Active  
Travel  
England

Your Ref: 23/01233/OUT  
Our Ref: ATE/23/00144/OUT  
Date: 11 July 2023

## Active Travel England Planning Response Detailed Response to an Application for Planning Permission

**Site Address:** OS PARCEL 4347 EAST OF PIPAL COTTAGE, OXFORD ROAD, KIDLINGTON, OX2 8HE

DRAWN	CHECKED	APPROVED
PH	JDW	JDW
PROJECT No:	SCALE @ A1:	DATE:
ITB16565	1:500	13.01.23
DRAWING No:	ITB16565 - SK - 067	
		REV: H

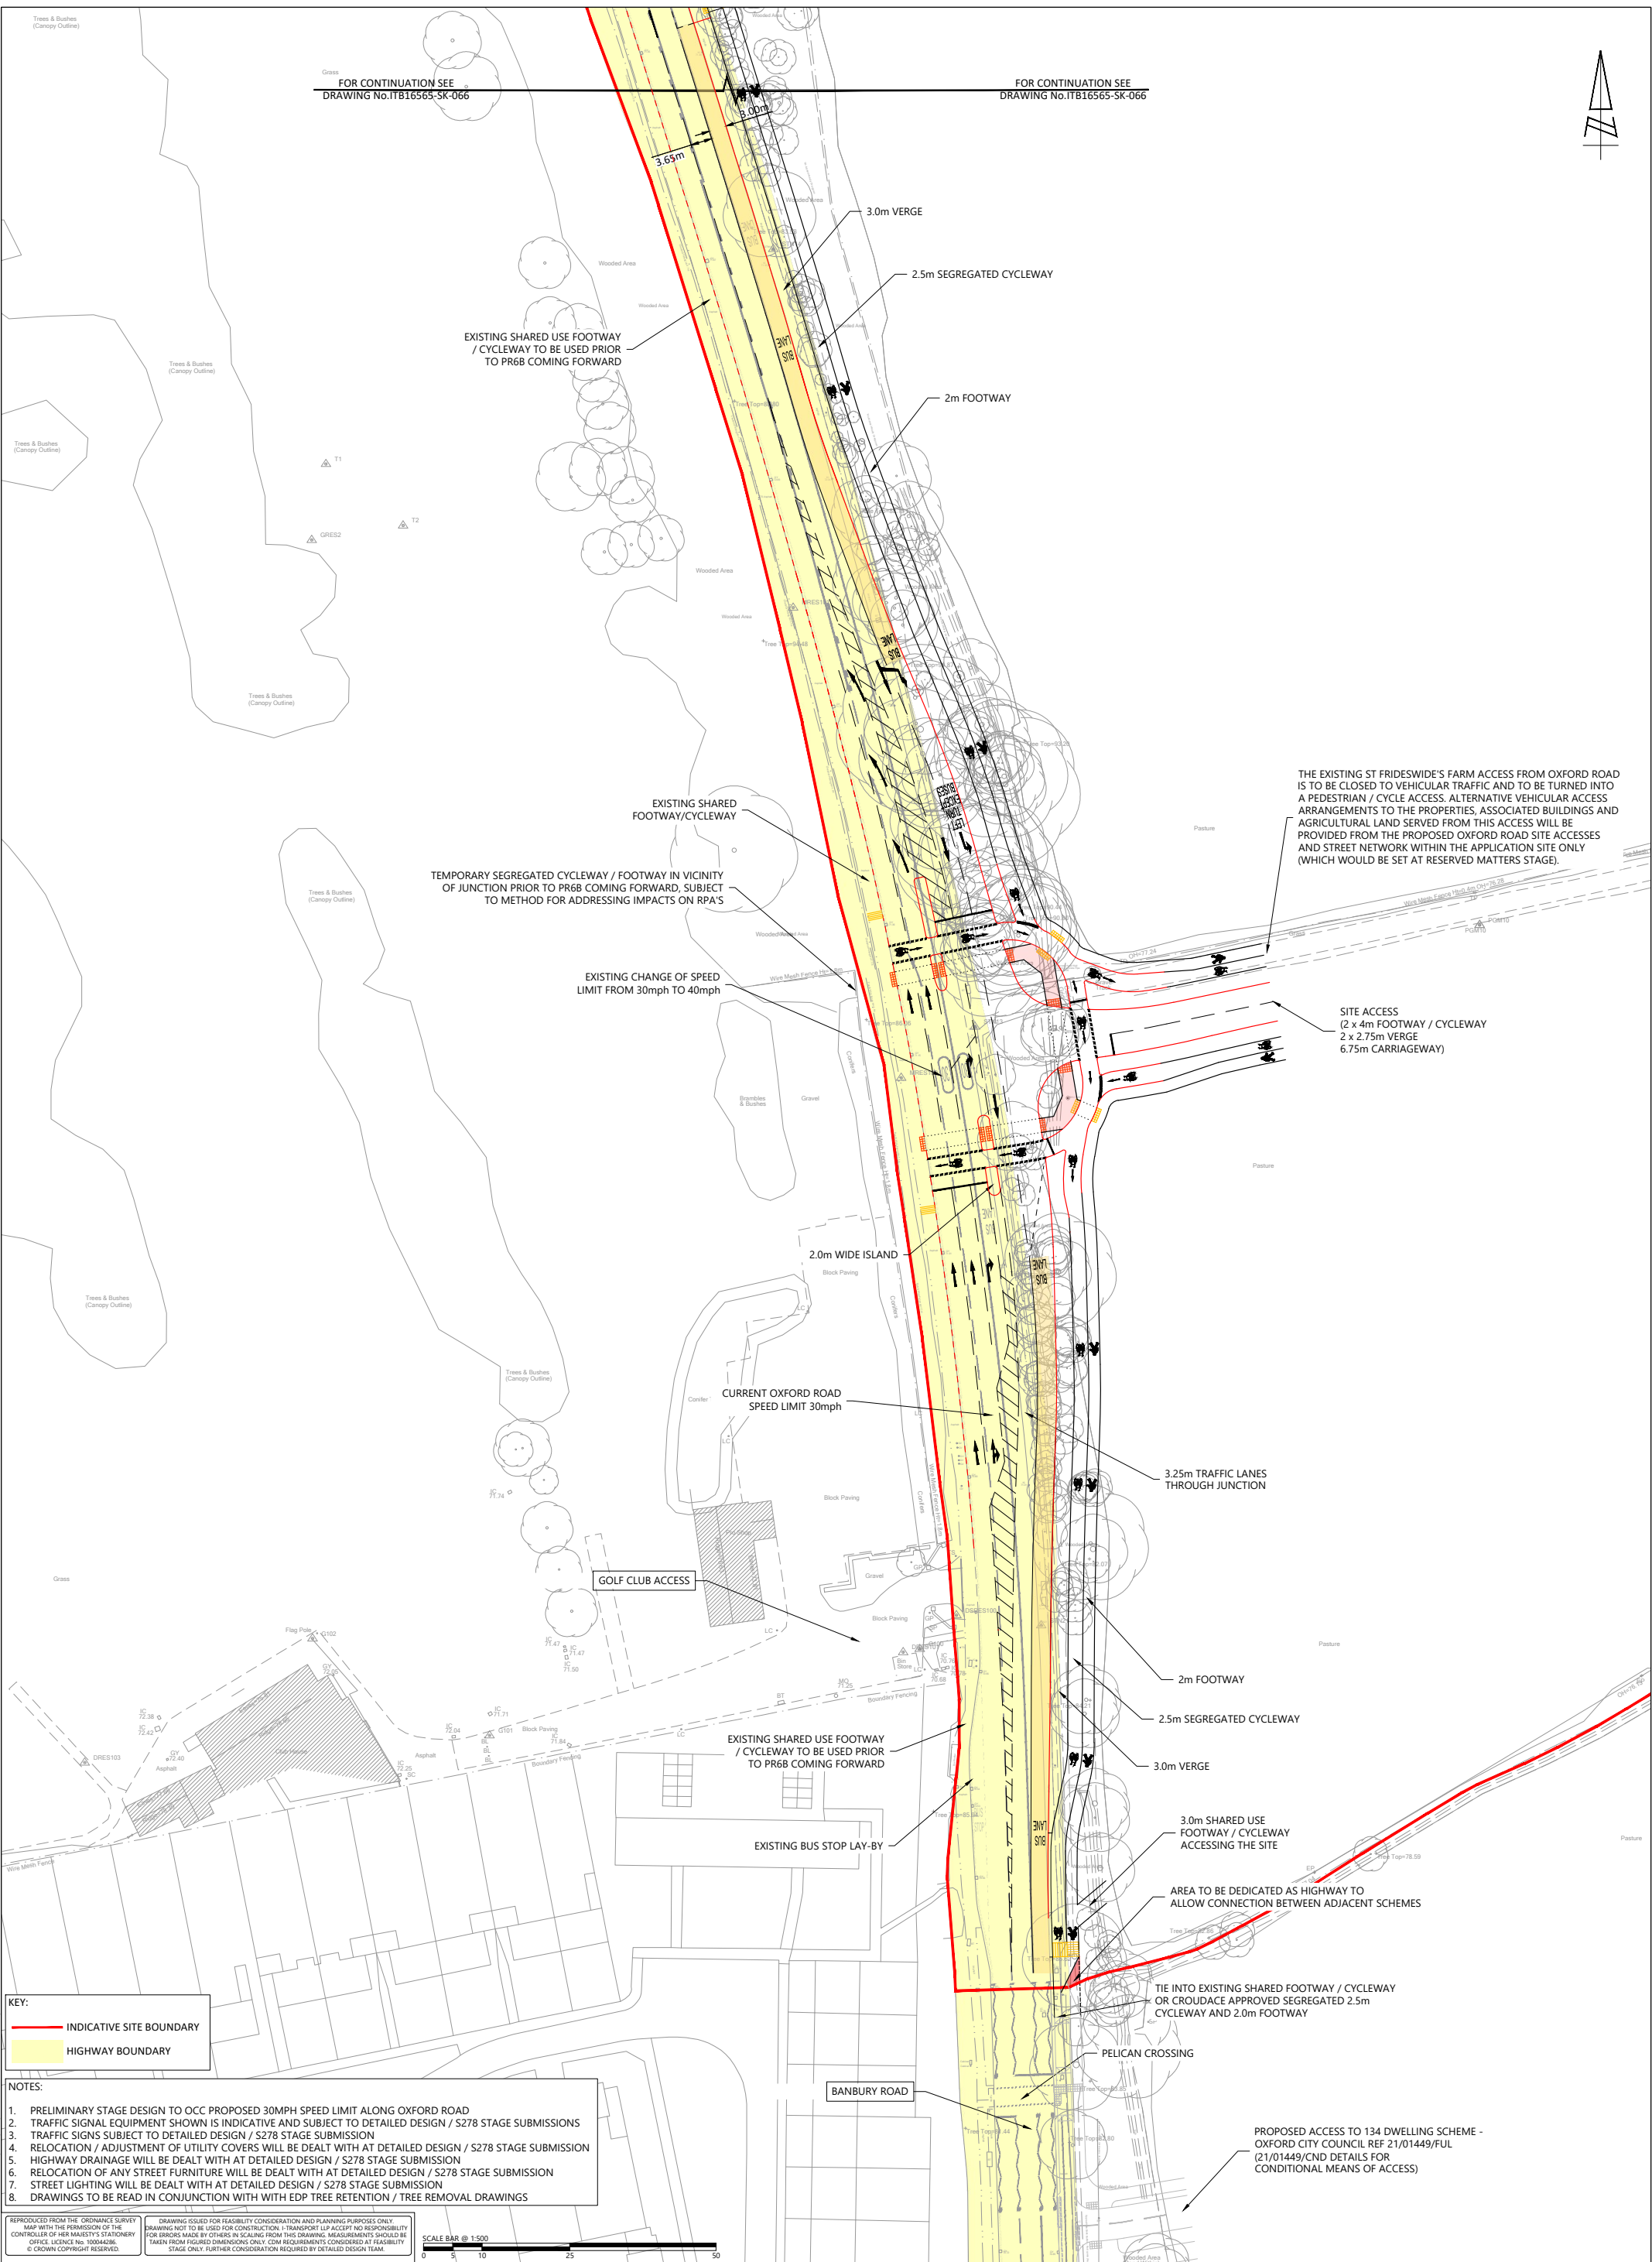
ATE considers it essential that confirmation of through routes is agreed upon at the outline application. Further confirmation is needed on the through - connections with the consented site south of the application site by Croudace and through routes to Cutteslowe Park.

ATE does not consider the existing highway infrastructure along Oxford and Banbury Road suitable for active travel due to its lack of width and segregation. ATE notes that the

development will contribute proportionately towards the OXCC cycle highway scheme, the potential Kidlington roundabout improvements and the enhancements proposed to the NCN Route 51 – avoiding Cutteslowe Roundabout. ATE would welcome confirmation of this agreement.
